# **Green Hill Solar Farm**

## **EN010170**

### **Change Notification**

Document Reference: CR1/GH9.1

GREEN HILL SOLAR FARM
Figure 4.15 Revision B
Green Hill Site E (2)
Landscape and Ecology Mitigation Plan
(EN010170/EX3/GH4.4.15_B)
5(2)(a)

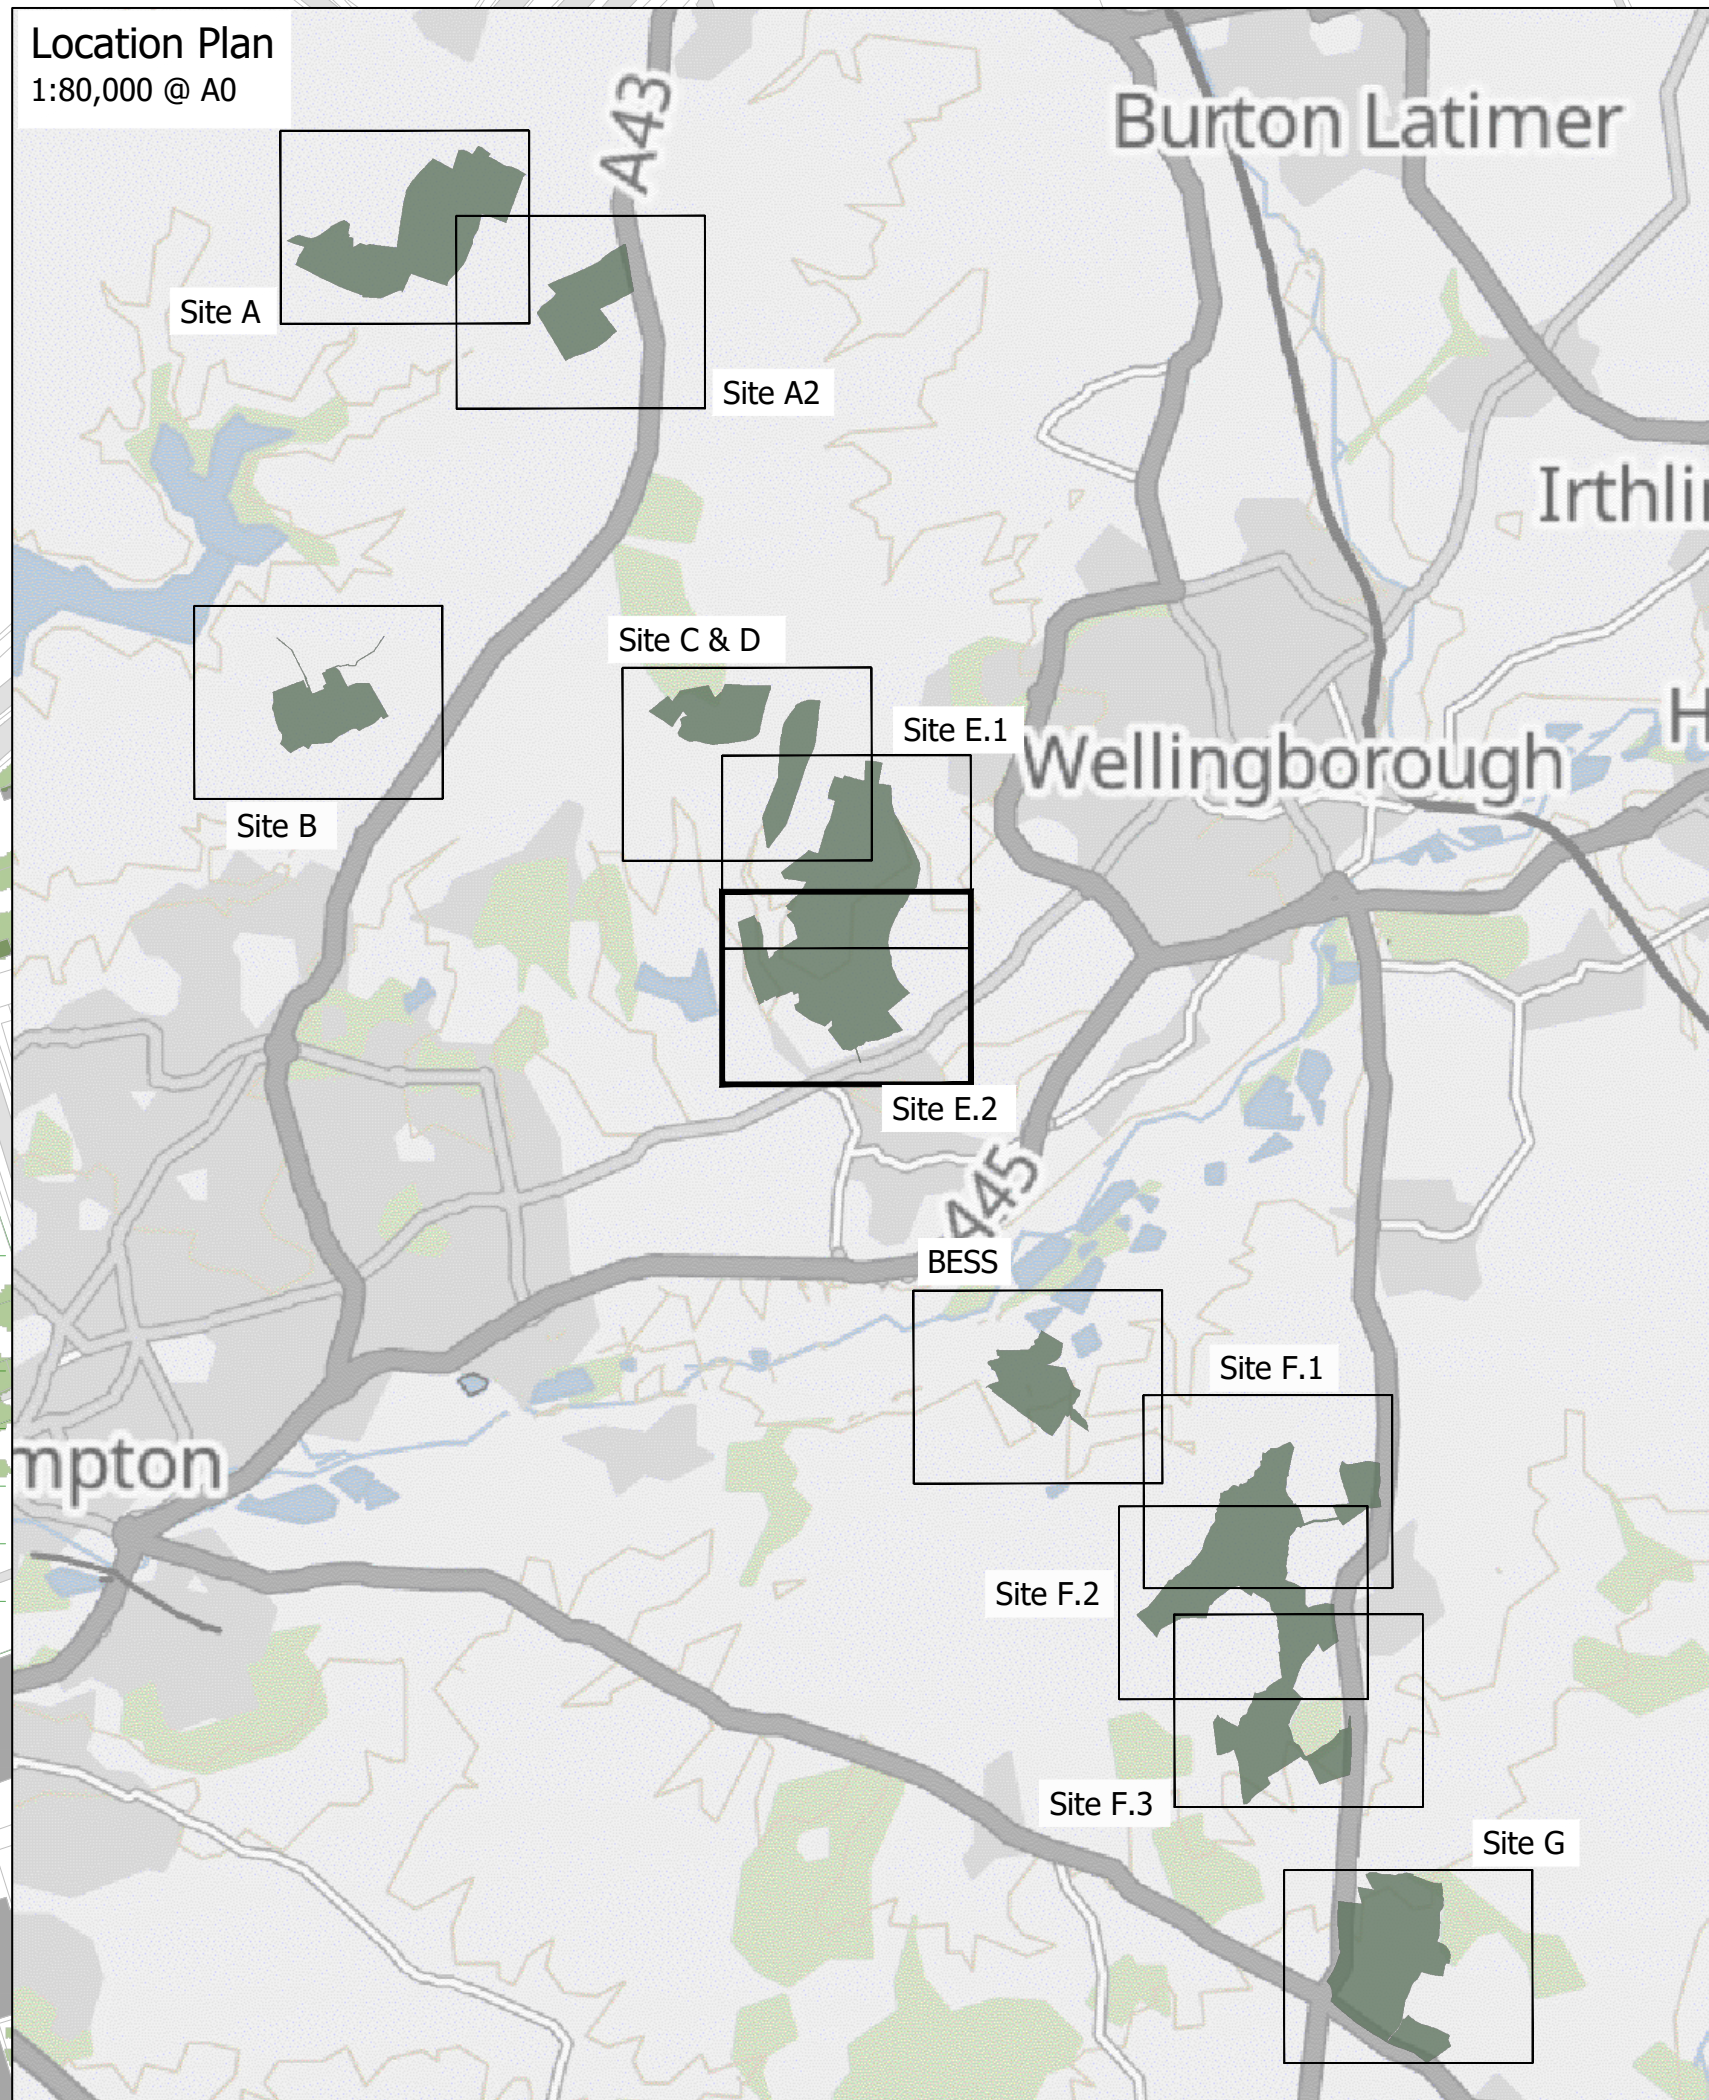
- 2.7 Change 6: Extension of Permissive Path at Green Hill E**
- 2.7.1 Change 6 comprises an extension to the Order Limits on the western side of Green Hill E. A detailed post-submission review by the Applicant of the proposed

permissive paths within the Scheme indicated that the proposed permissive path within Green Hill E did not adjoin a publicly accessible route. This change is proposed to connect the permissive path to Byway Open to All Traffic, reference TN/010, allowing members of the public to reach the new permissive path from the public highway without having to cross private land. The area of the land to be added to the Order Limits is approximately 0.03ha. This land will be subject to compulsory acquisition of the freehold and shown in pink on the updated Land Plan.

Figure 4.17 Revision B
Green Hill Site F (1)
Landscape and Ecology Mitigation Plan
[EN010170/EX3/GH6.4.4.17_B]
5(2)(a)

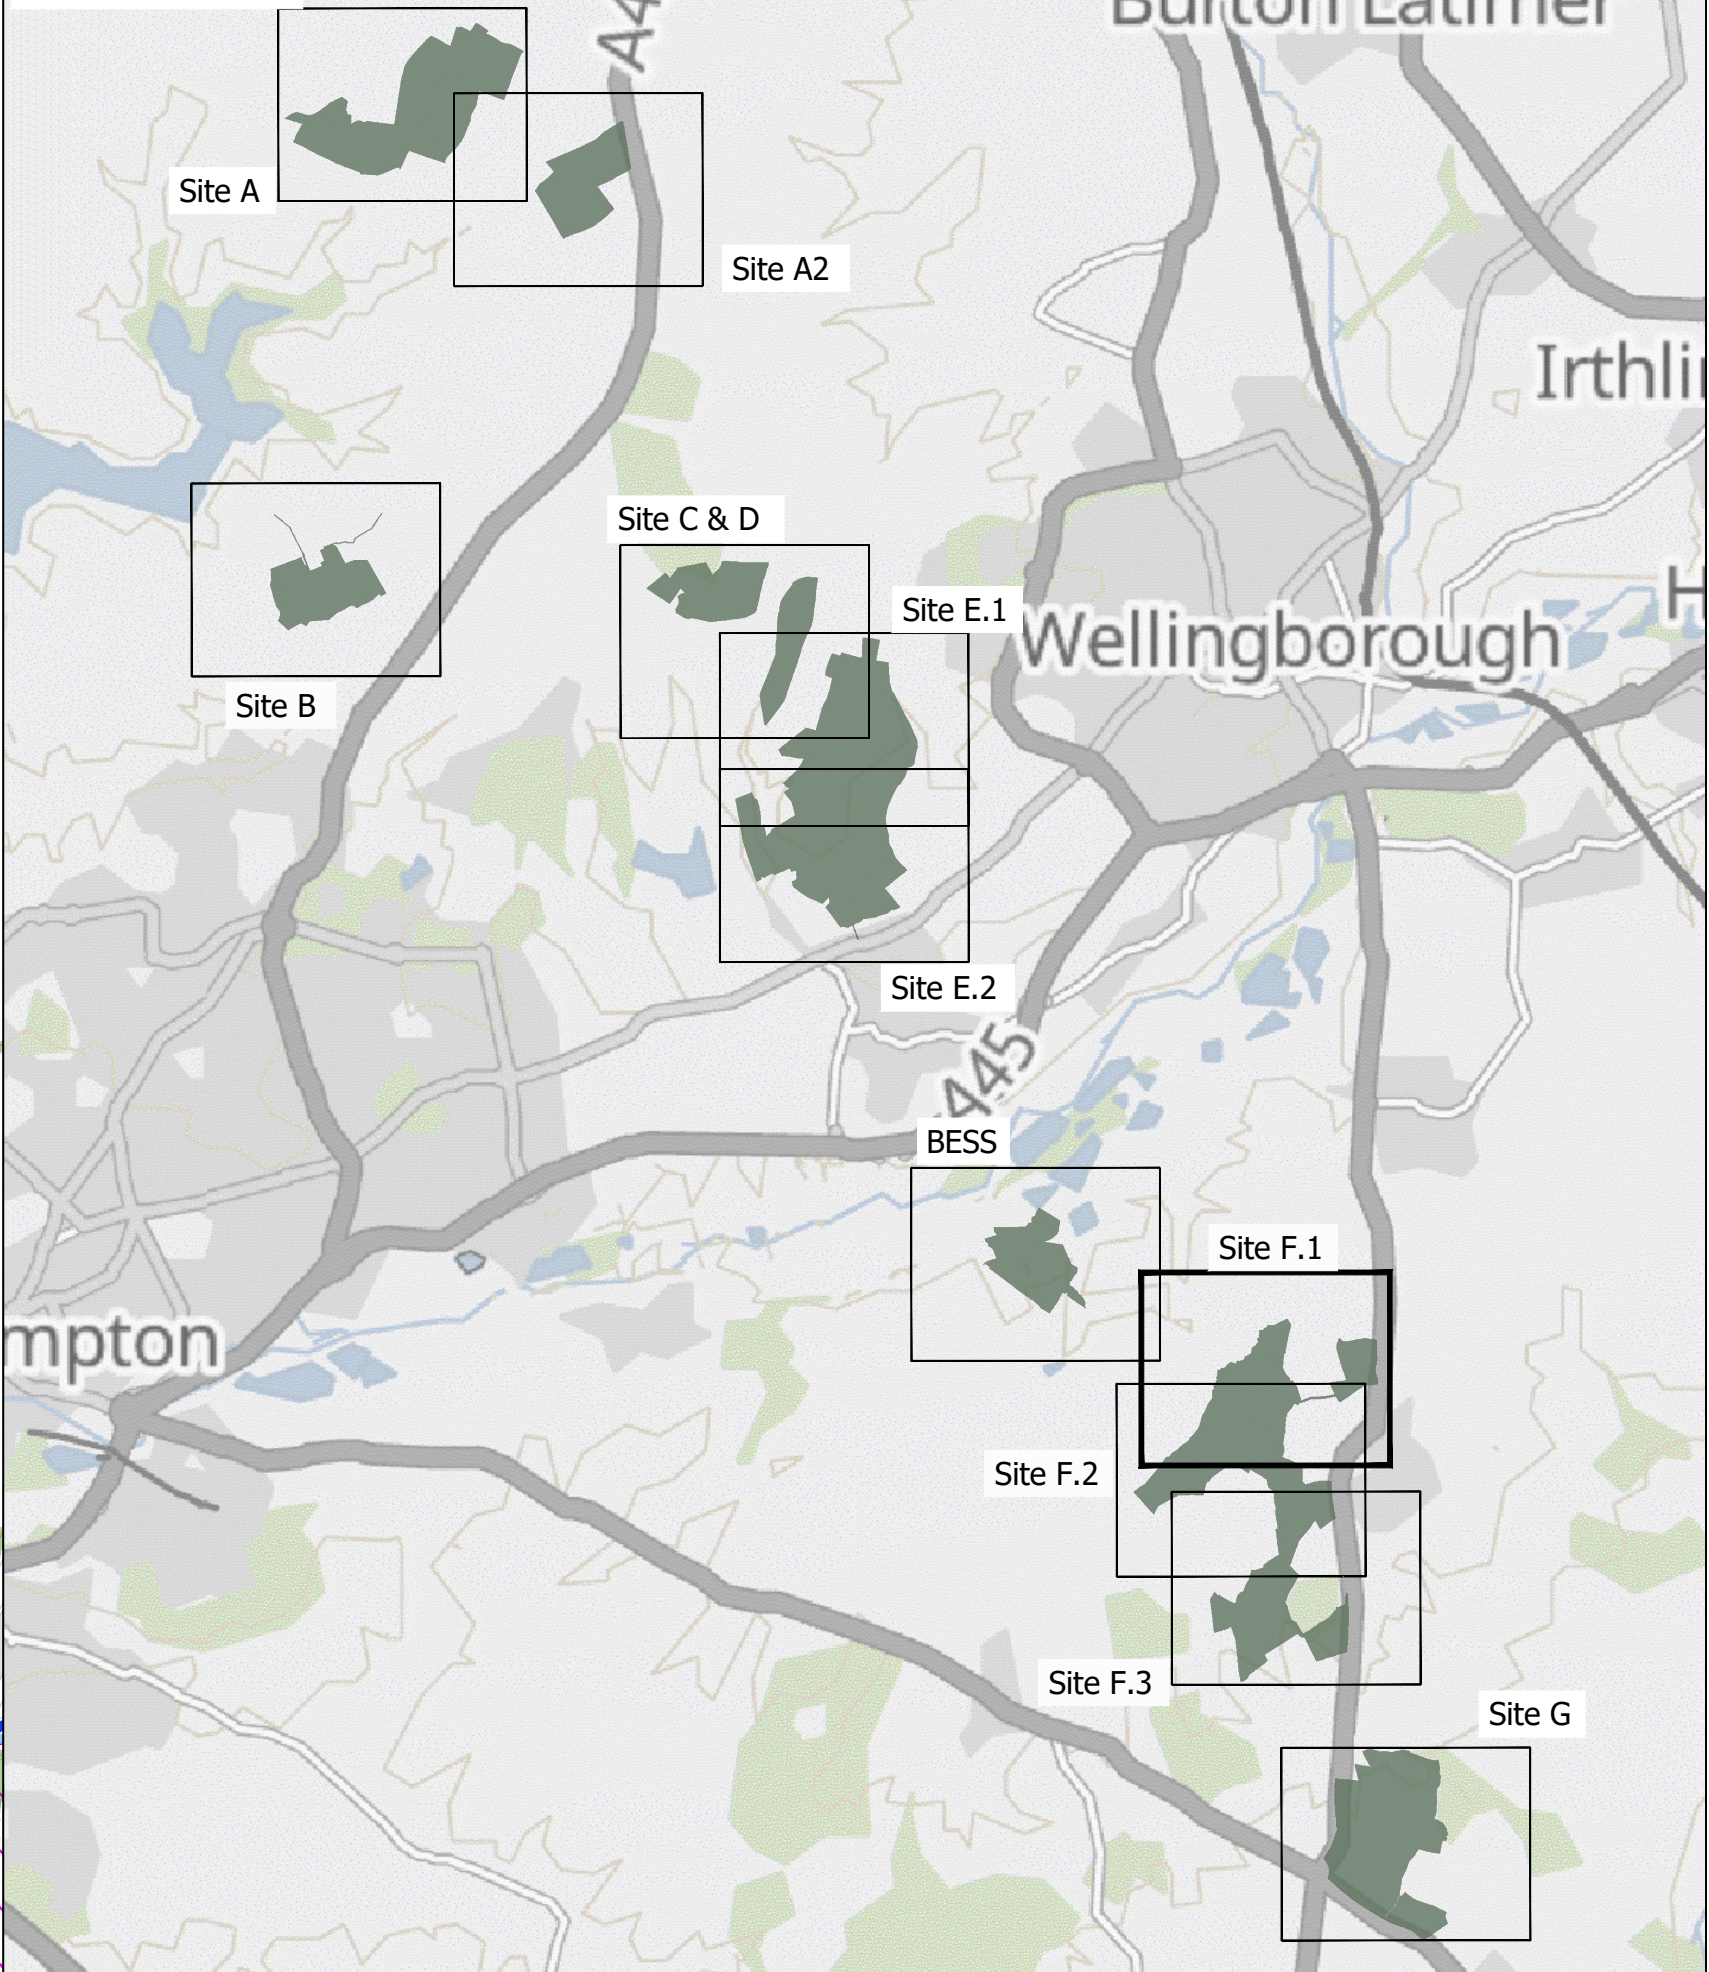
## **2.9 Change 8: Removal of Area from Order Limits within Green Hill F**

2.9.1 Change 8 comprises a change to the Order Limits of a small parcel of land located to the north of the watercourse that forms the northern boundary of Green Hill F.

2.9.2 A post-submission review by the Applicant of the land plans along this watercourse indicated that a small area of land extending to approximately 0.03ha was separated from Green Hill F by the watercourse and therefore could not viably be incorporated into the Scheme. It is therefore proposed that this area of land be removed from the Order Limits.

## **2.10 Change 9: Removal of Area from Order Limits and Change to Compulsory Acquisition Status within Green Hill F in proximity to Horn Wood**

2.10.1 Change 9 comprises a change to the Order Limits and a change to the compulsory acquisition status to land in proximity to Horn Wood within Green Hill F.

2.10.2 The proposed construction and operational access for Green Hill F follows the route of an existing farm track from the A509 to the solar panel area. Part of this track is adjacent to Horn Wood ancient woodland and local wildlife site. A detailed post-submission review by the Applicant against page 14 of ES Chapter 27: Commitments Register [APP-064] indicates that the works required to reinforce the track for construction, replacement and decommissioning activities would be required within the buffer around ancient woodland and therefore had the potential to cause harm to the trees of the ancient woodland. Realigning the track

to create a larger buffer from the woodland would reduce or eliminate this harm. Two changes are therefore proposed. Firstly, it is proposed that the compulsory acquisition status of an area to the east Horn Wood is increased from temporary possession powers (yellow) to permanent acquisition of rights only (blue) on the Land Plan by splitting plot 16-210-a. This area will also be included within Work No 8B. This will allow for the creation of a permanent access outside of the buffer area. The affected area extends to approximately 1.07ha.

- 2.10.3 Secondly, it is proposed that a section of the existing farm track immediately adjacent to Horn Wood to the southwest, with an area of approximately 0.25ha, be removed from the Order Limits by removing part of plot 15-207 to ensure that the track is not used in relation to the Scheme.
